Building

Energy

① M - HRV LEVEL 1  
3/16" = 1'-0"

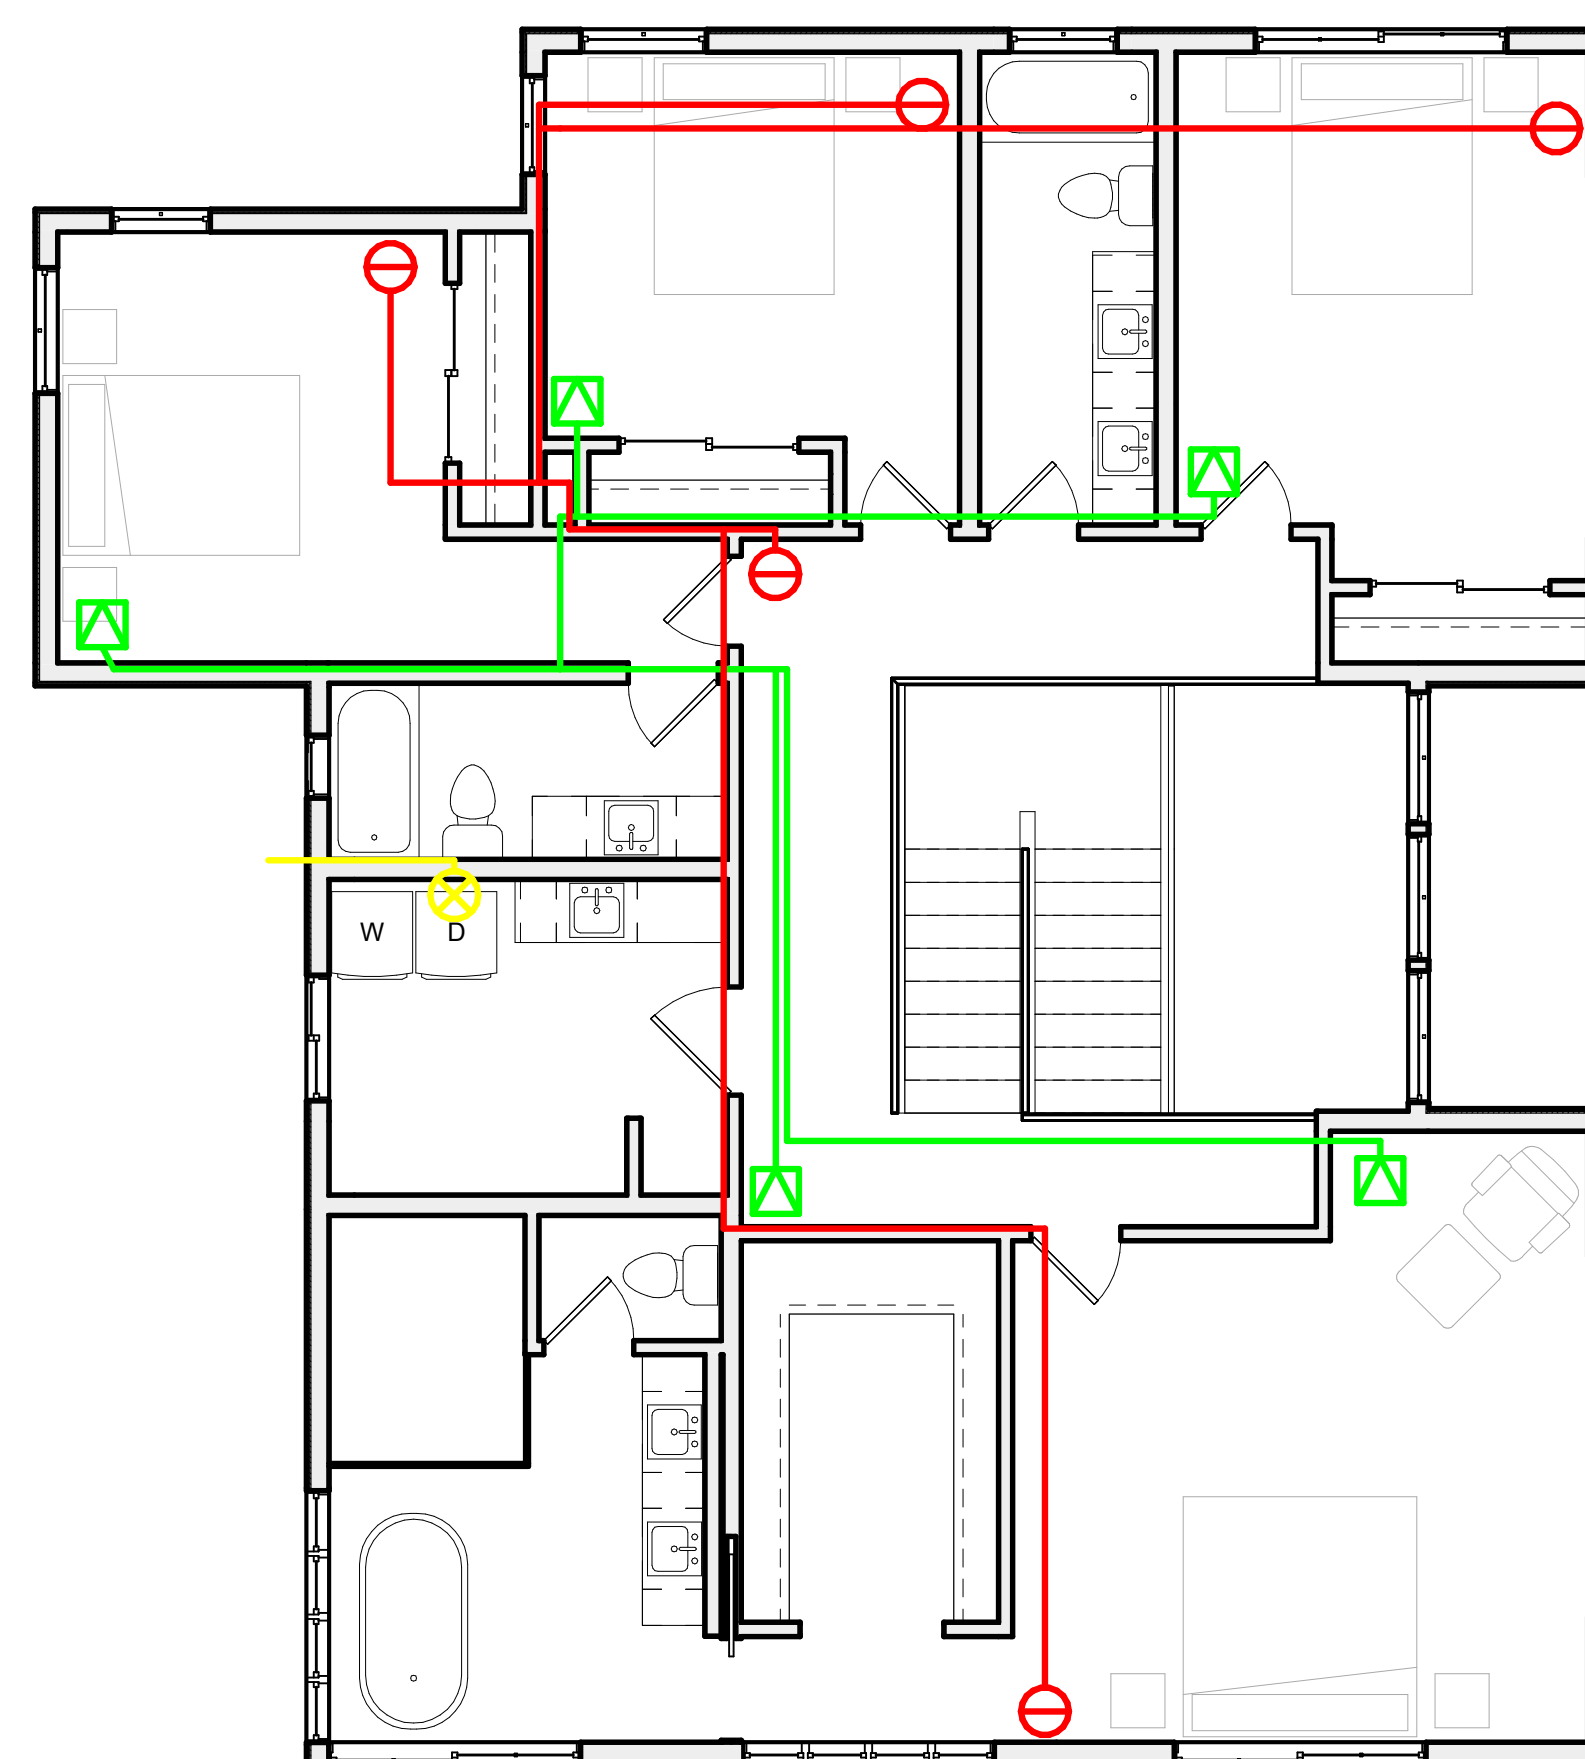
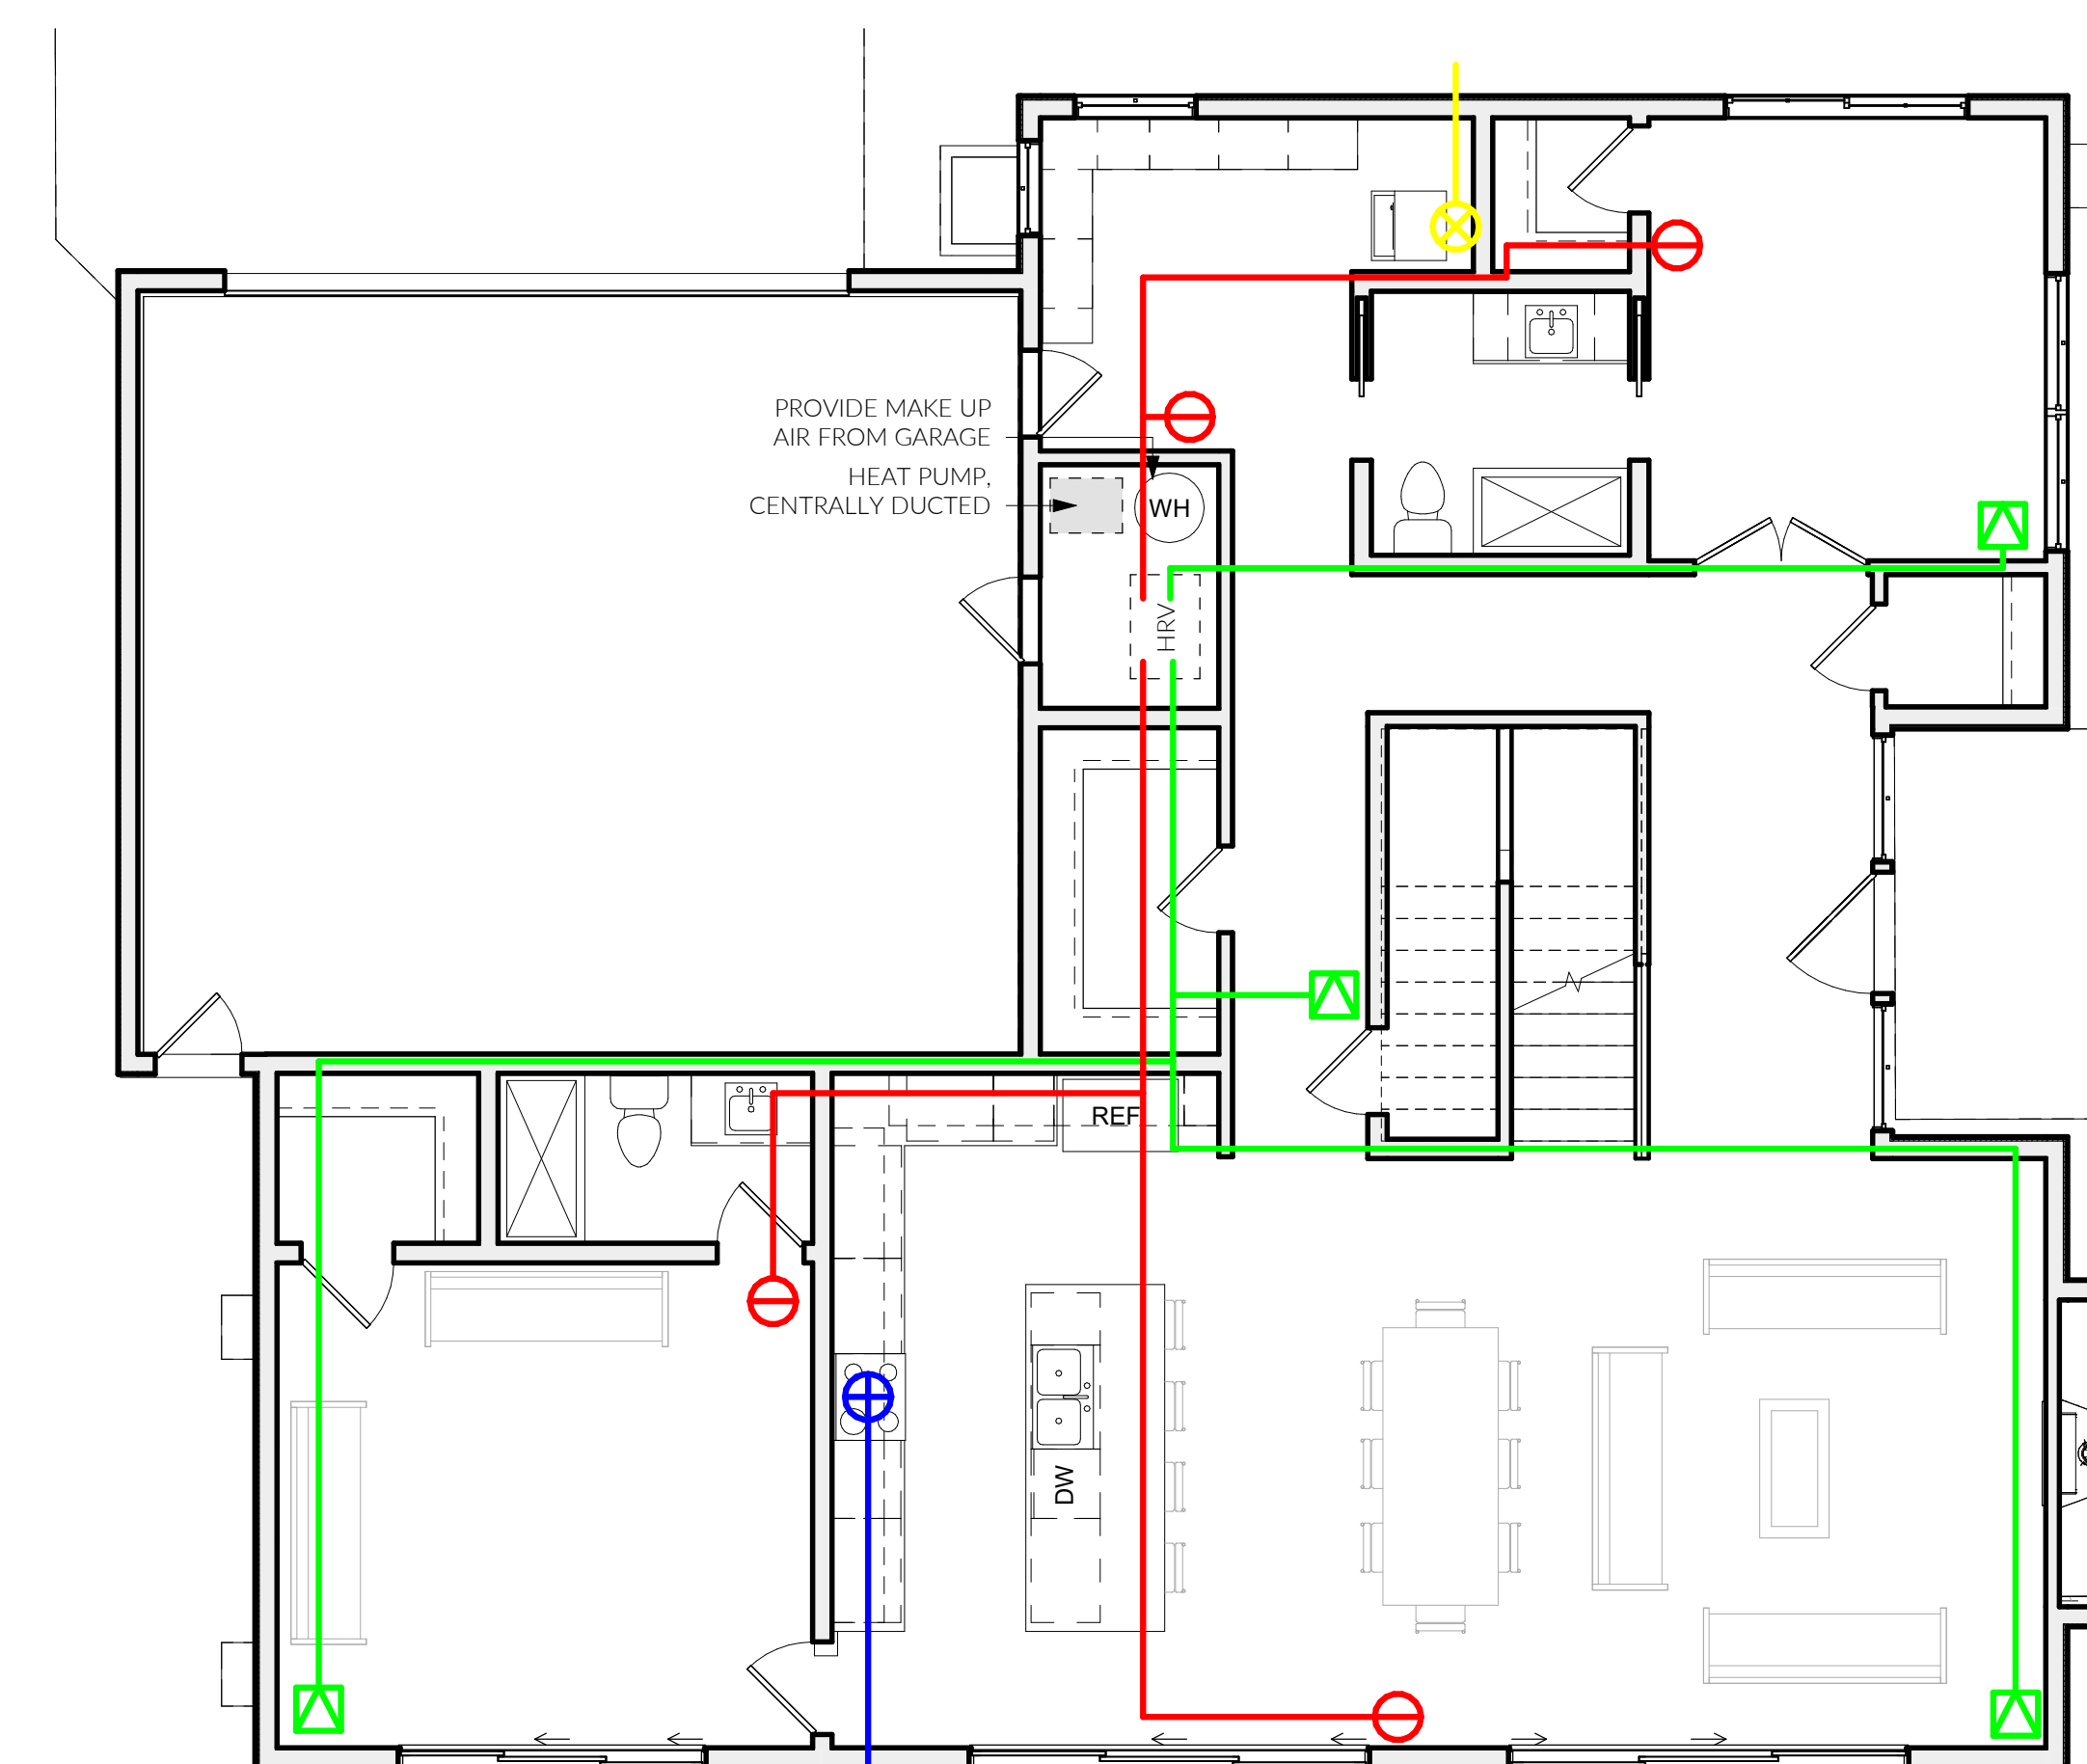
- 1.) Since the heating system sizing calculations are only on a separate document, please include the maximum heat equipment output sizing information on the drawings.
/// Maximum heat equipment output sizing information added to sheet M1.0.
- 2.) The location of exterior mechanical equipment must be clearly indicated on the drawings. We assume the heat pump will be on the exterior and the air handling unit will be on the interior. It is unclear where the exterior equipment for the heat pump is to be located.
/// Sheet M1.0 revised with exterior unit locations for heat pump w/central air handler.

- 7.) Please update the notes on Sheet M1.0 to refer to the IRC, not the SRC.
/// Notes revised to call out IRC, not SRC. Please see updated notes on sheet M1.0.

- 8.) Per IRC M1505.4.1.1, whole-house ventilation fans must be rated for sound at a maximum of 1.0 sone. This sound rating shall be at a minimum of...
/// Note added to sheet M1.0 calling out maximum sound rating of 1.0 sone.
